St Anthony of Padua Catholic School Redevelopment (SSD-8865)
Request for Additional Information

I refer to Response to Submissions (RtS) for the St Anthony of Padua Catholic School Redevelopment (SSD-8865). After careful consideration, the Department is requesting that you submit additional information that effectively addresses the issues identified in **Attachment 1**.

DRAWING
DETAILED PROPOSAL
STAGE 4 PLAN

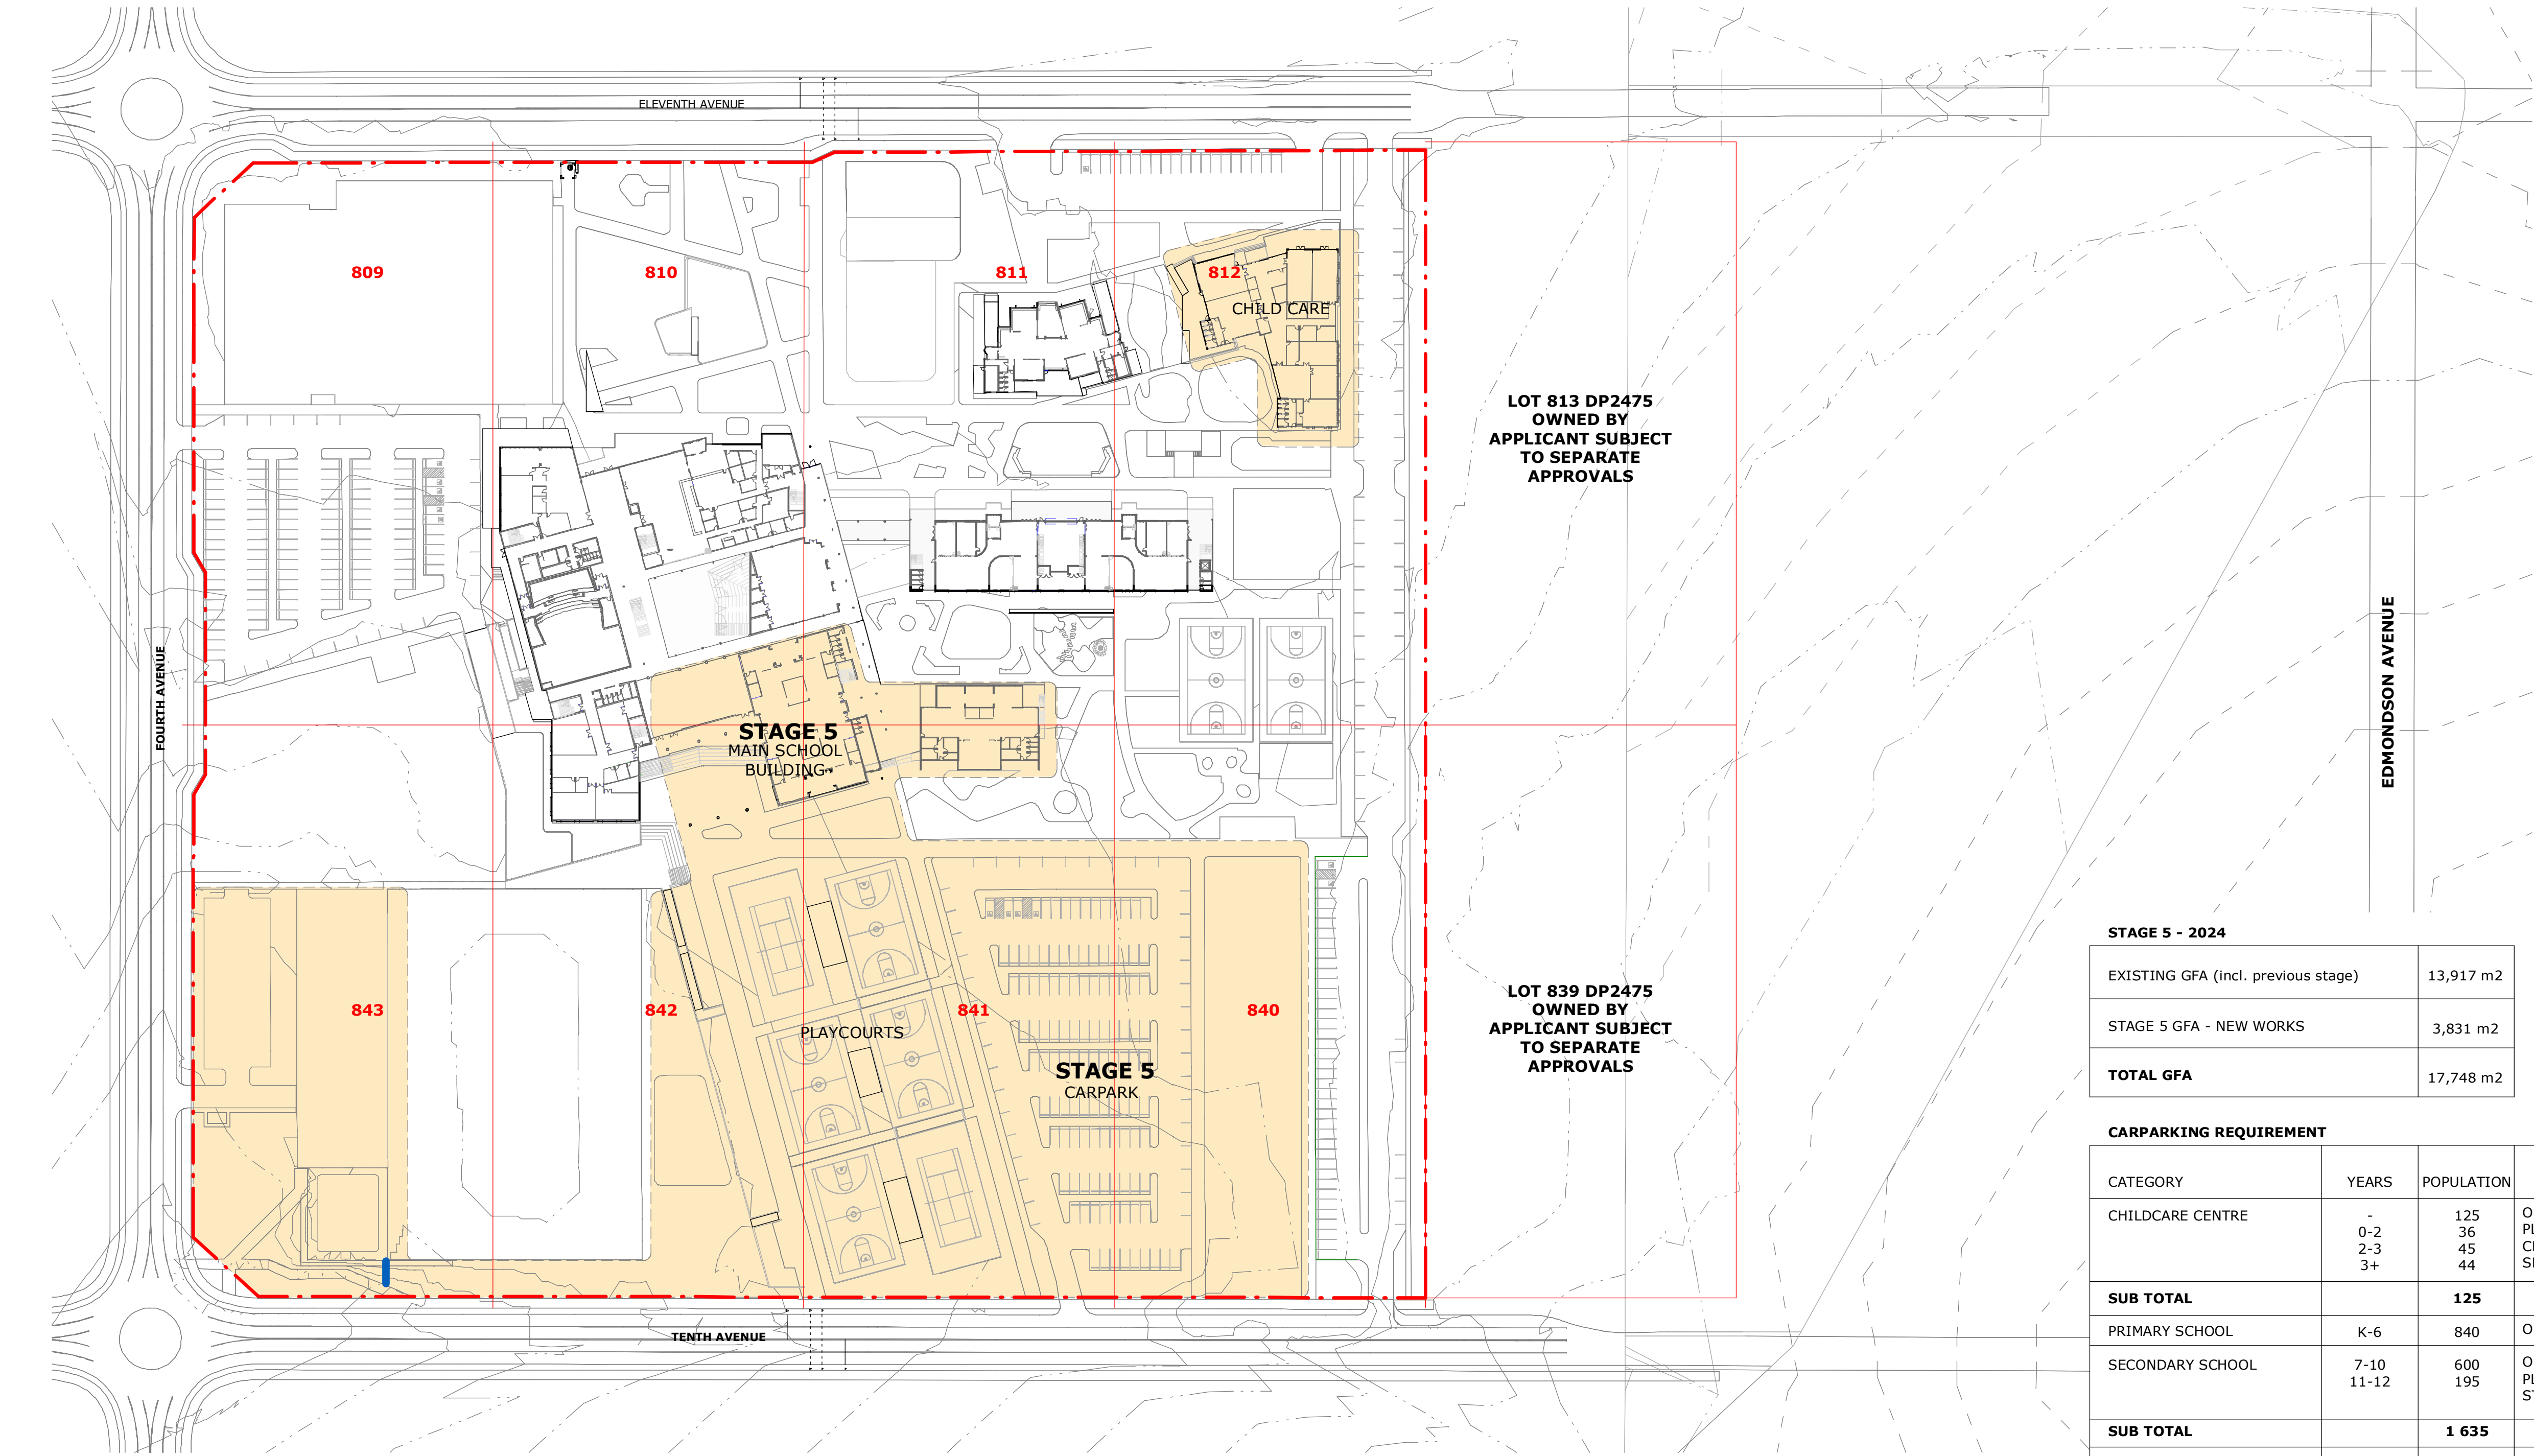
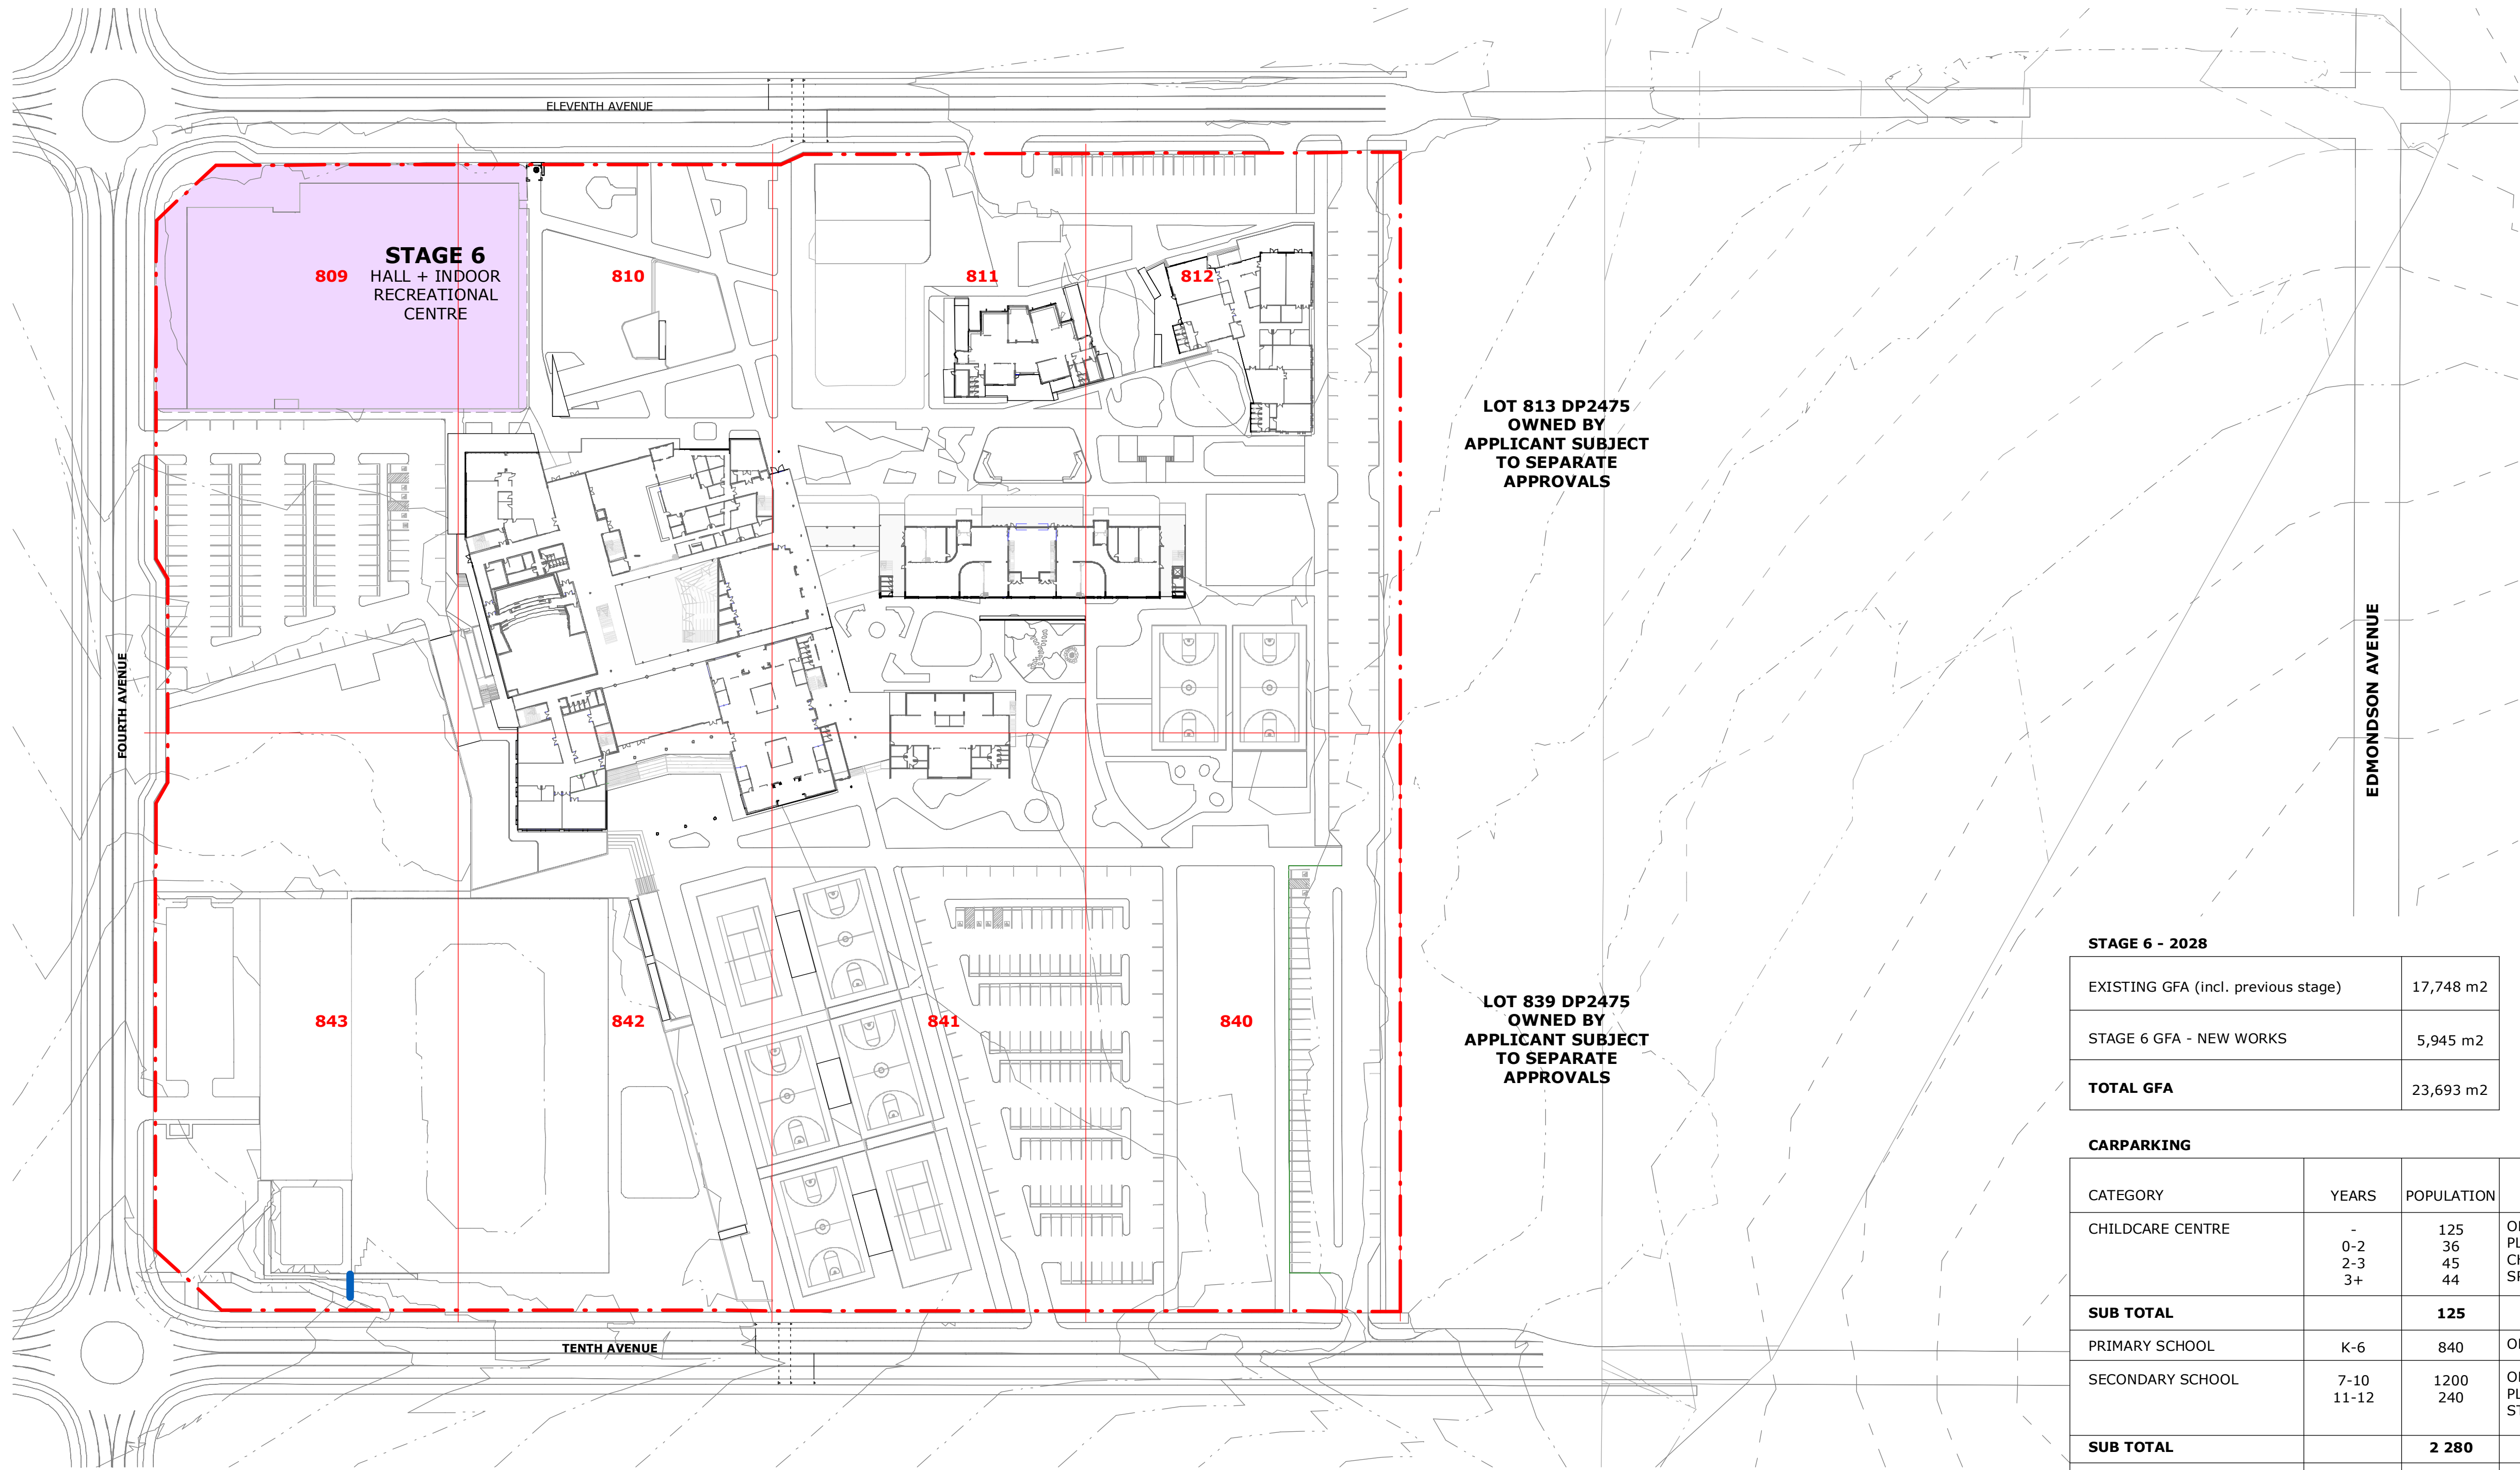
- a single (integrated) staging plan should be submitted that includes all construction stages in one plan.

- the central section of the eastern drop-off and pick-up area (on the internal road) and landscaping to the east of the central hub building have not been included in any of the construction stages. The Staging plans should be amended to include these works.

- the staging plans do not clarify whether the demolition works / remediation works tree removal would be undertaken prior to any works on the site or whether these works would also be undertaken in stages. Should these works be undertaken in stages, the following matters are required to be separately justified:

- the gross-floor area for each construction stage.
 - The correct number of car parking and drop-off and pick-up spaces for construction Stage 4 noting that the existing information is incorrect (177 car spaces) as it does not include the proposed 22 drop-off and pick-up spaces.

1 DIAGRAM - FENCING PLAN
1 : 1000

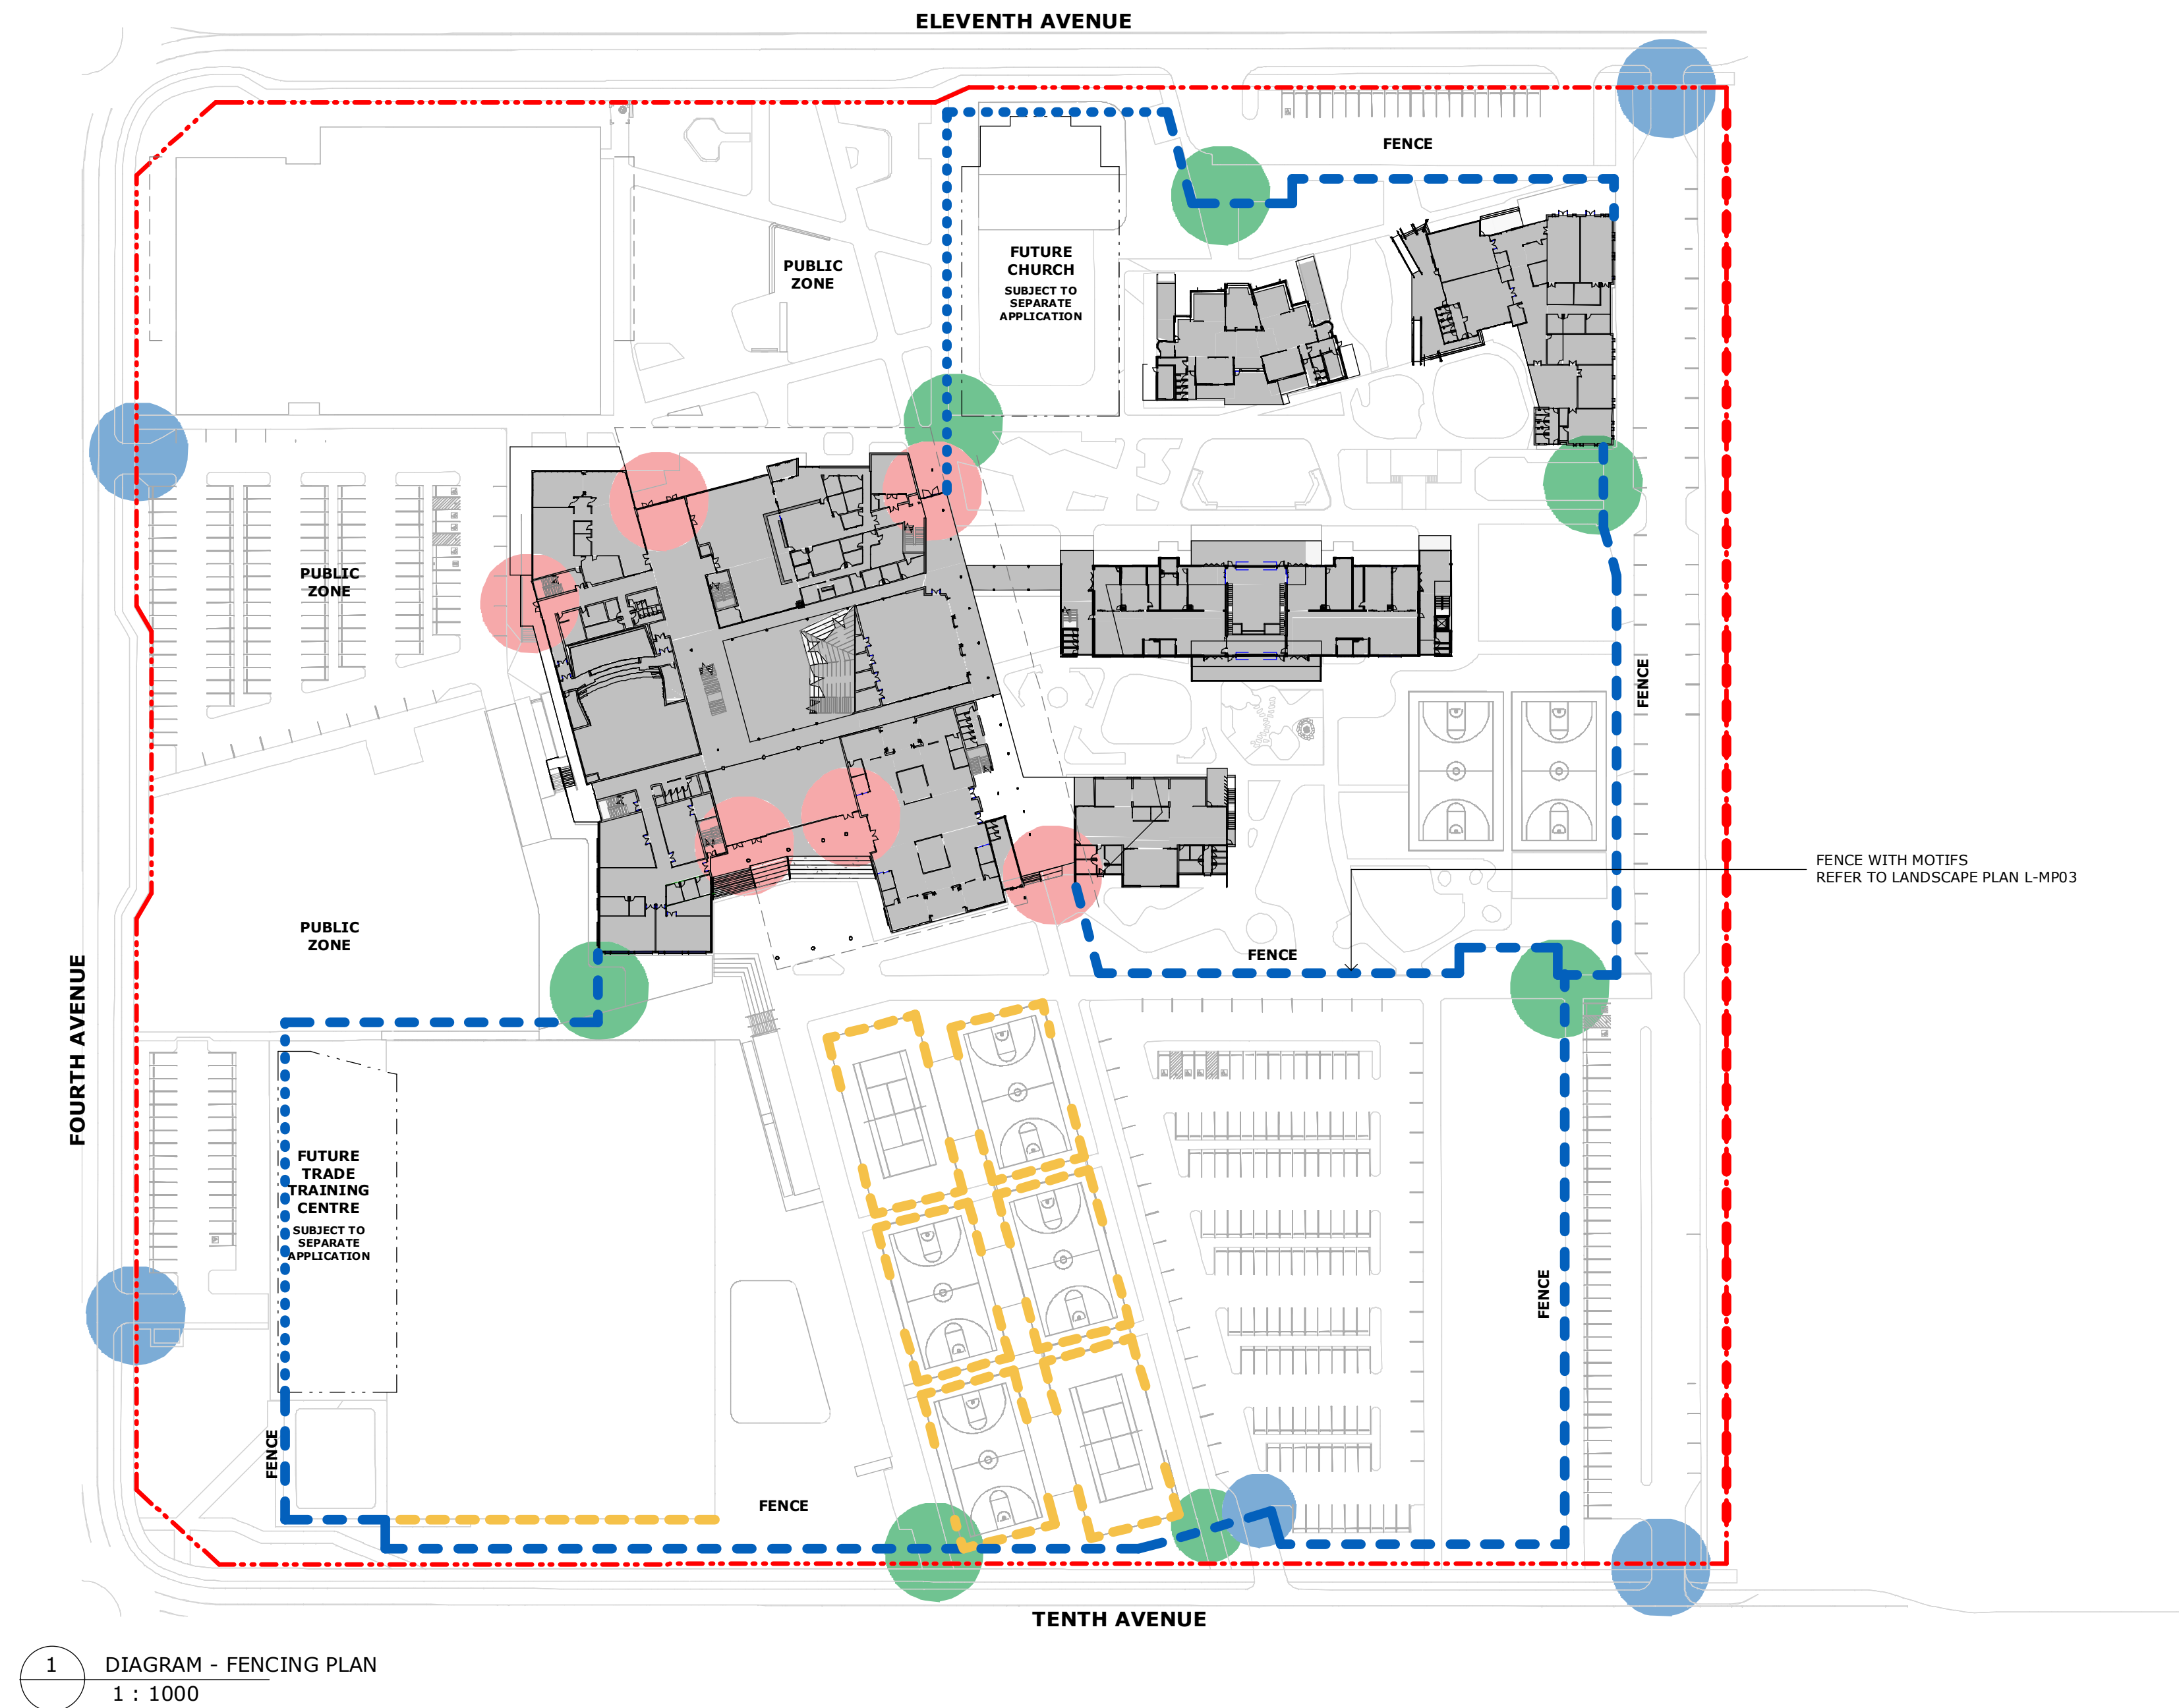
- elevations and details of the proposed fence design and height should be submitted.
- landscape plans for the Stage 1 works should be submitted separate to the Concept Proposal drawings. These plans should reflect the proposed landscaping works in stages within the site.
